RFI

RFI #: 175
Date: 7/27/2012
Job: EB-02 Keller Springs Lofts
Phone: 877-777-5115

Subject: Air handlers and CFM columns

**A2-SP ONE BEDROOM/ONE BATH**  
SCALE 1/4"=1'-0"

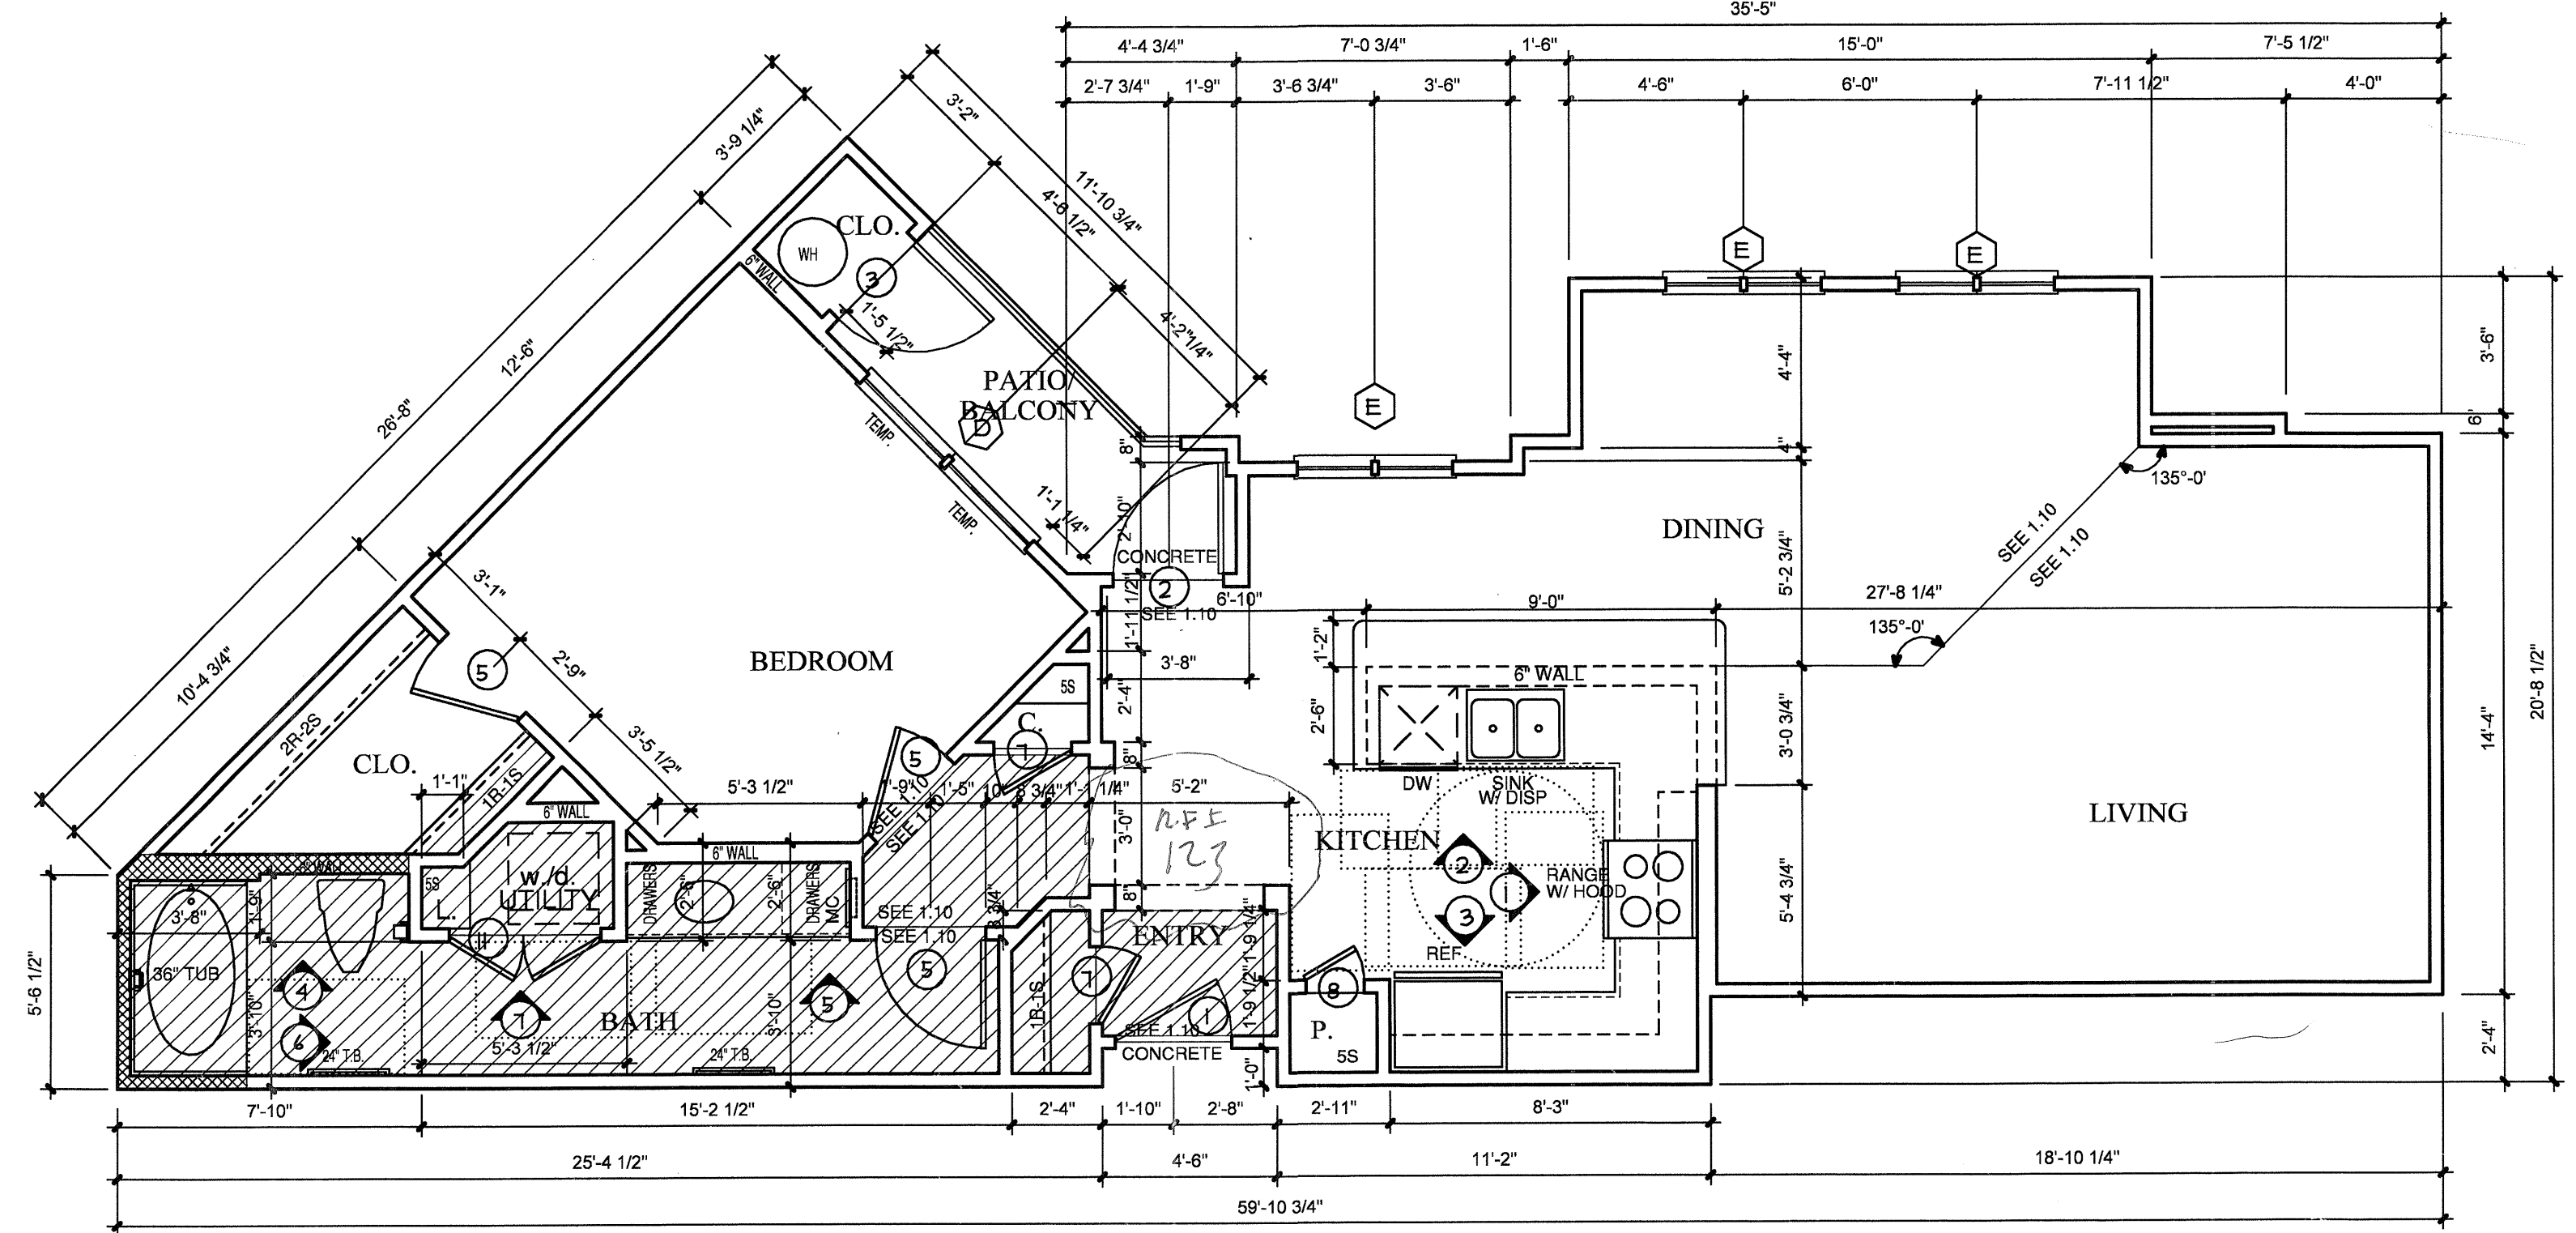
Request: **Date Required:** 6/22/2012
4/M-2.2 shows no fur down over washer/dryer unit in A2-SP, sheet 2.3A shows A2-SP with fur down. Please clarify and advise.

No furrdown is required over the washer/dryer.
